From: Jennifer Pollitt [REDACTED]
Sent: 24 January 2022 21:13
To: Planning.Responses <Planning.Responses@arun.gov.uk>
Subject: RE: Planning Consultation on: AB/136/21/PL

Application No: AB/136/21/PL

Site Address: Land Adjacent 18 Queens Lane Arundel BN18 9JN

Description of Works: Demolition of garage and erection of two dwellings with associated car parking and landscaping. This application is in CIL Zone 2 and is CIL liable as new dwellings.

Figure 1: Habitat Survey Map

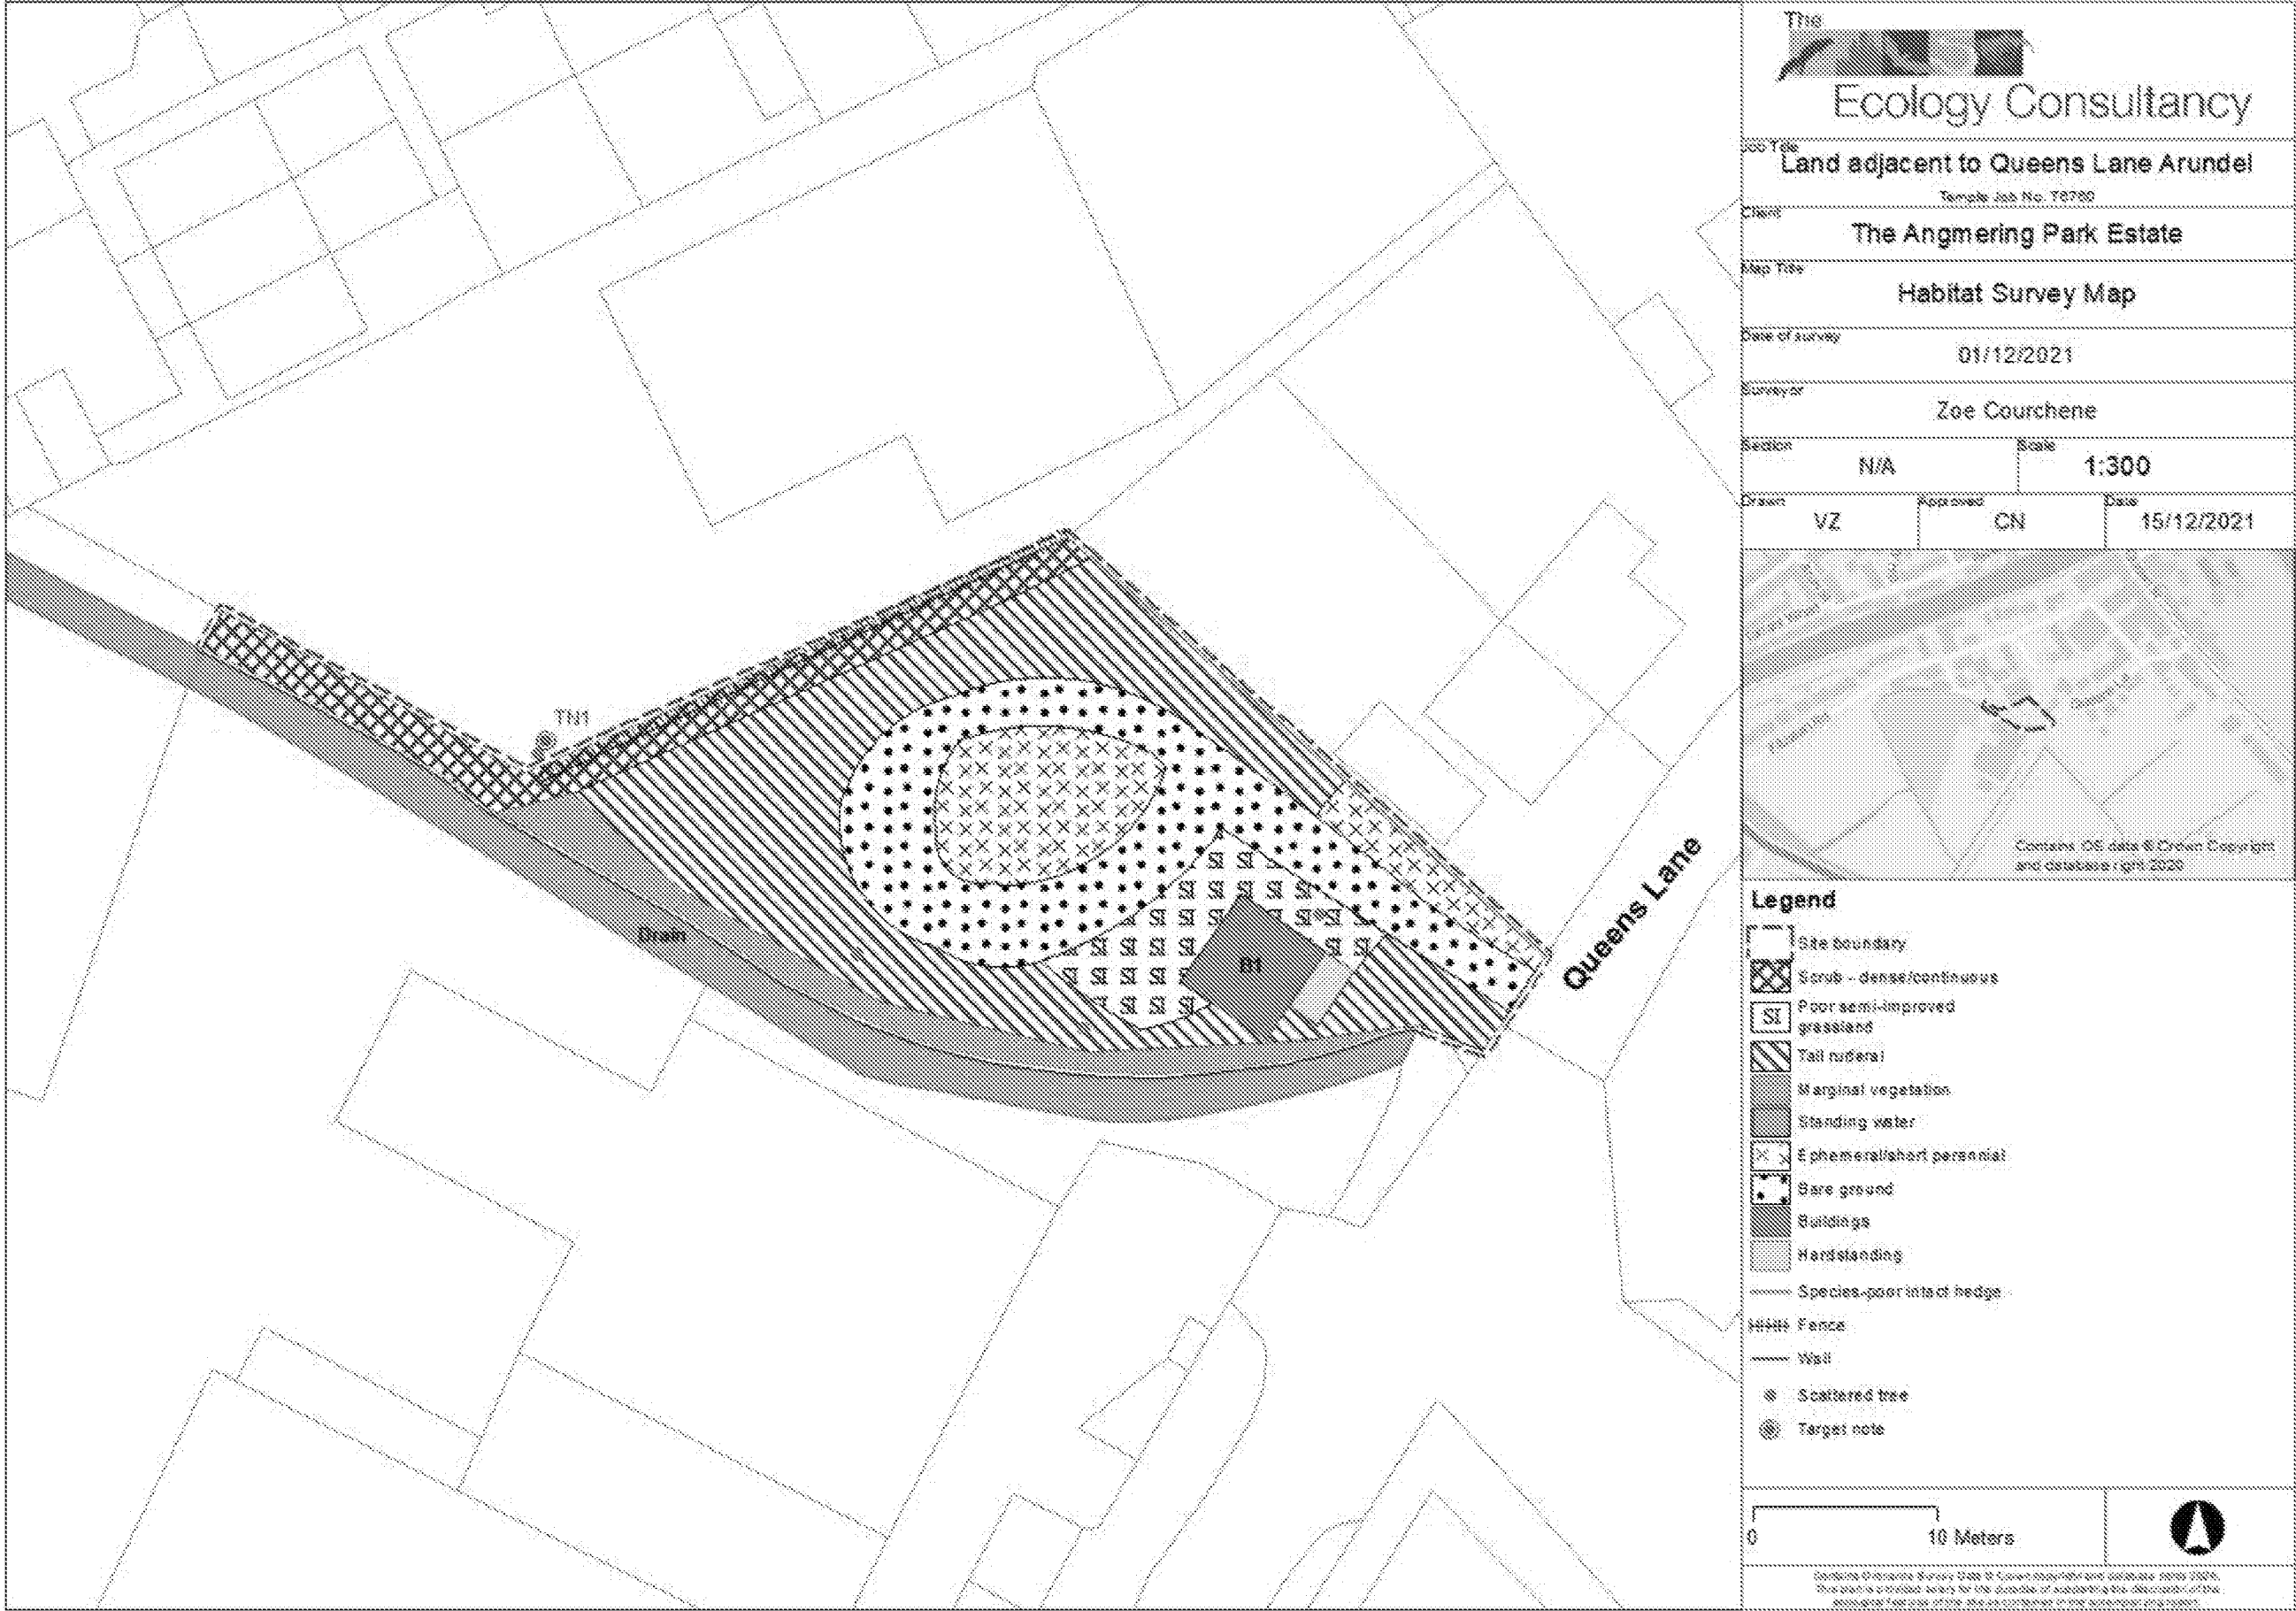
To ensure no habitat degradation occurs best practice guidance as detailed in the PEA (Jan 2022) should be observed. Conditions should be used to ensure this.

As detailed in the PEA (Jan 2022), T1 has moderate suitability for roosting bats. To prevent any bat roosts from being disturbed this tree should be safeguarded from development.
